OBJECTION TO APPLCIATION REFERENCE 2024/62/91242/E

I grew up in Thurstonland and now live in Stocksmoor with my family. I am saddened by this proposed development and have many objections; however, I would like to focus my objection on the clear issues regarding intensification of traffic on Stone Wood Lane and access to the site. The developers have attempted to underplay these issues through the Transport Assessment report of Andrew Moseley Associates. This report has numerous failings, which I will highlight in my objection.

<b>27/03/2024</b> <b>AMA/20547</b> <b>Figure 7</b>	<b>Shepley Road, Stocksmoor</b>	- Drawn by: SD Checked: AMM	<b>AM</b> <b>08:00 - 09:00</b>
	<b>Proposed Trip Distribution (%)</b>		<b>PM</b> <b>17:00 - 18:00</b>
			<b>SAT</b> <b>N/A</b>

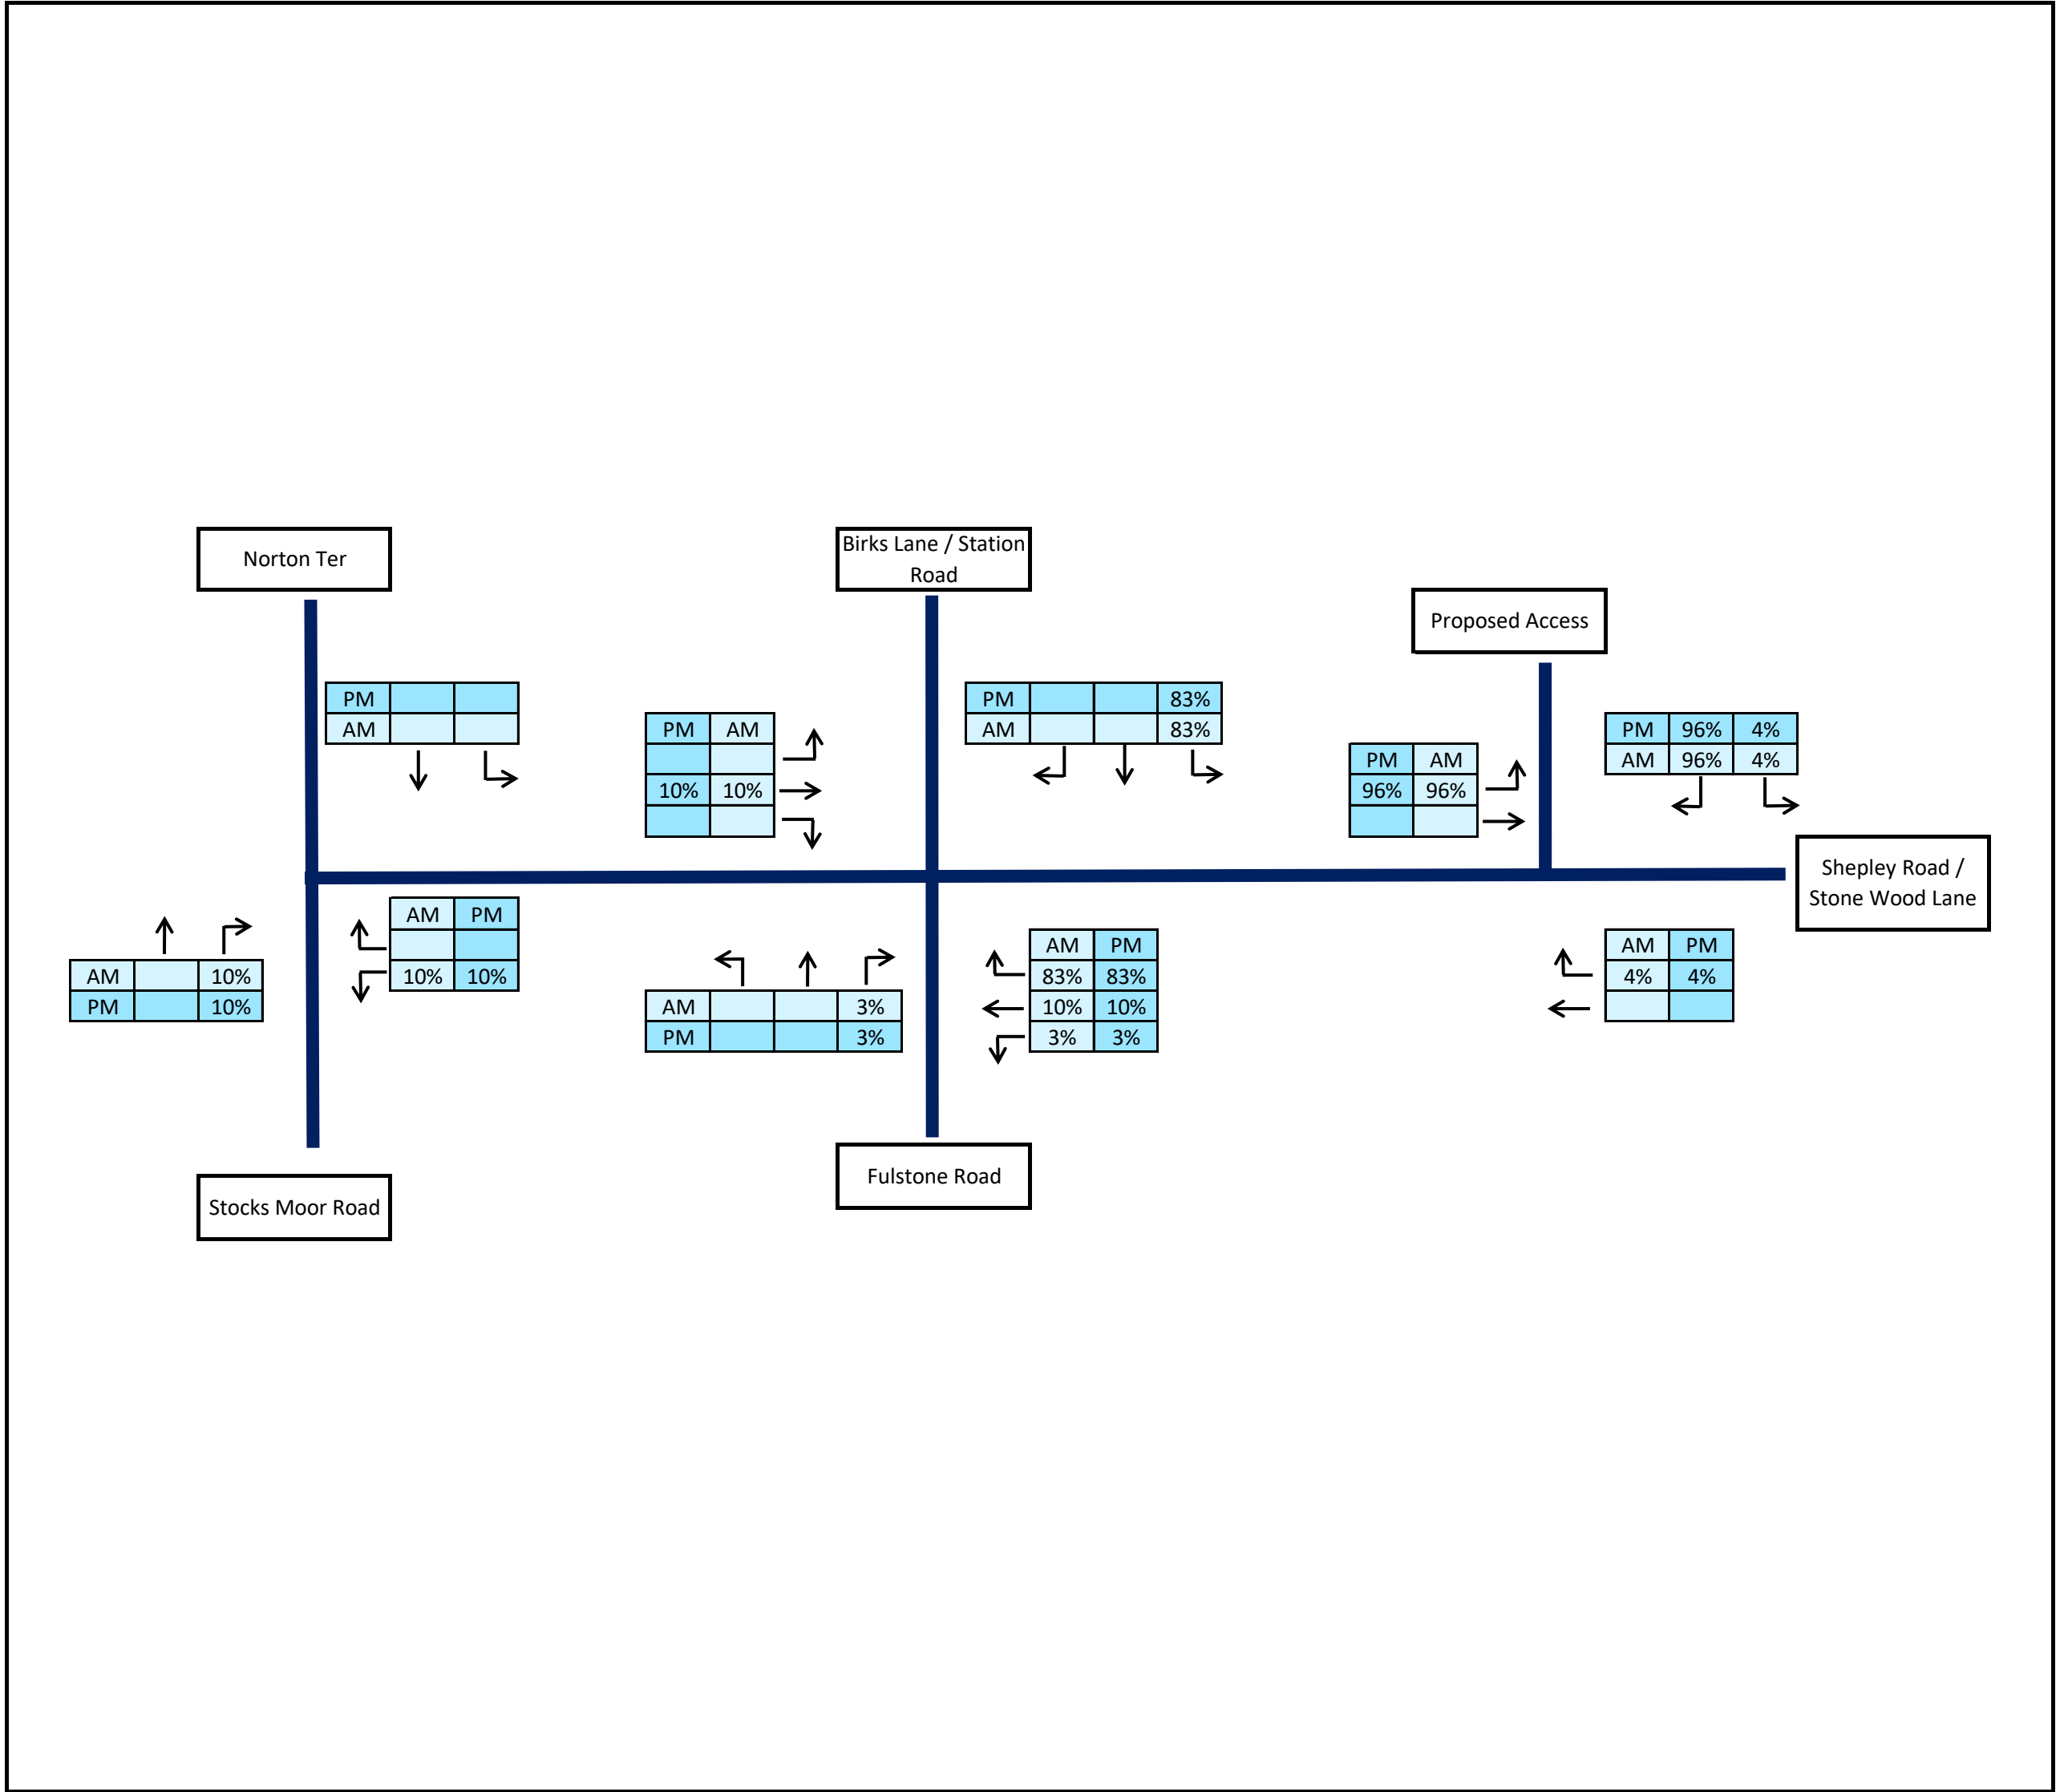
*The 'model' predicts that 4% of the traffic from the development will embark/return from their journey via Stone Wood Lane, with the remaining 96% heading to the crossroads. These figures are arrived at through an extrapolation of crossroads data that is not representative of the actual routes taken by residents of the hamlet.

*With the above figures, the model predicts that at most 1 vehicle from the development will use Stone Wood Lane during the peak AM and PM hours. This figure is simply not plausible, which is not surprising given that it is based on erroneous extrapolations of data.

27/03/2024  
 AMA/20547  
 Figure 8

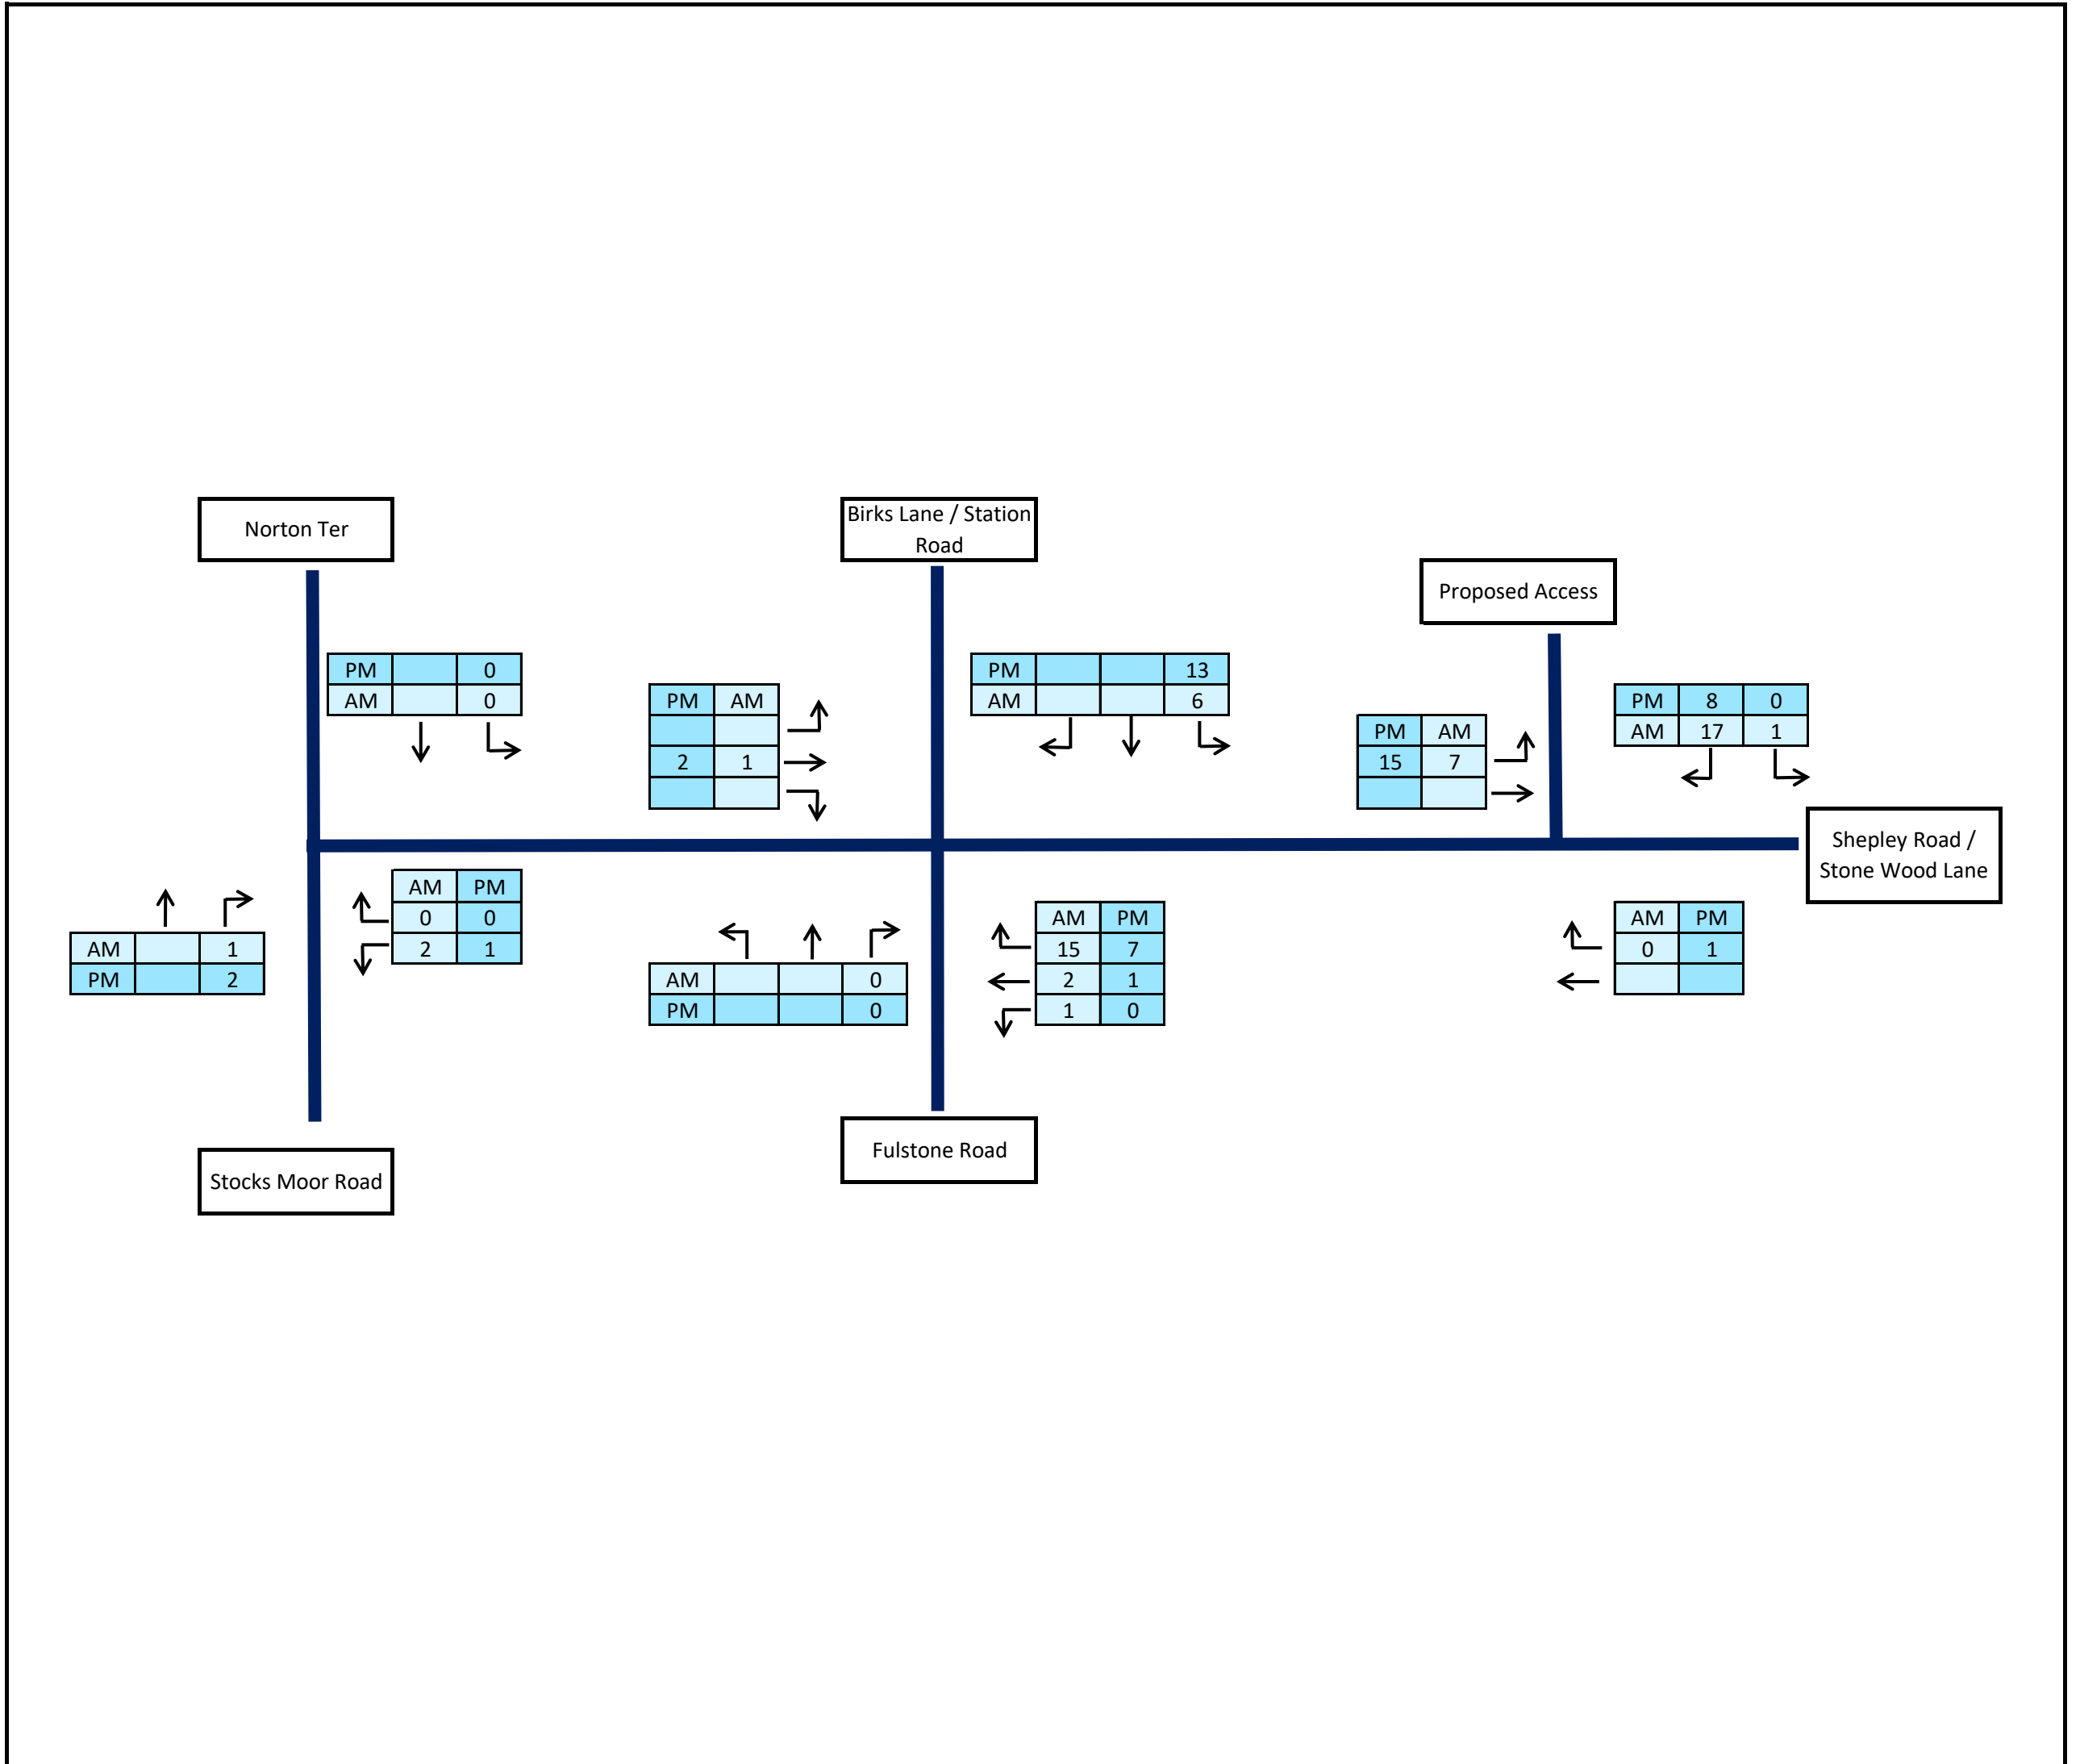
*Section 5 of the transport assessment includes an attempt at modelling the impact of the proposed development on traffic volume of Stone Wood Lane. This modelling is deeply flawed. Here, I will demonstrate that their modelling is not credible and leads to clearly implausible figures. Later, I will provide alternative figures, based on actual local data in the hamlet, that are likely to provide much better estimates of the true impact of the proposed development on traffic intensification.

*The 'model' generates 26 two-way vehicle trips in the AM peak hour and 24 two-way vehicle trips in the PM peak hour. These numbers are generated based on the TRICS trip rate database. However, given the fact that residents of Stocksmoor are reliant on cars for the vast majority of journeys, these numbers are not representative of the characteristics of the hamlet, and are likely to underestimate the number of vehicle trips.

*The report claims that being below 30 two-way vehicle trips in peak hours that the effect is not significant. I wish to stress that their figures are likely to be underestimates, and there is also a lack of context given here since even 24 two-way vehicle trips in peak hours is significant for a site located on bad bend situated adjacent to a single-track road.

*The model in the transport assessment generated 26 two-way vehicle trips in the AM peak hour and 24 two-way vehicle trips in the PM peak hour. Our figures are: 34 two-way vehicle trips in the AM peak and hour and 30 two-way vehicle trips in the PM peak hour. I would like to stress that these figures are now in excess of the 30-vehicle threshold mentioned in the transport assessment, and so this impact can be considered significant, especially in the context of a site that almost immediately joins on to a single-track road. Total peak AM traffic flow on Shepley Road would increase from an average of 63.2 vehicles per hour to 97.2 vehicles per hour, for an increase of 54%. Total PM peak traffic flow on Shepley Road would increase from an average of 69 vehicles per hour to 99 vehicles per hour, for an increase of 43%. These are clearly significant increases in traffic volume.
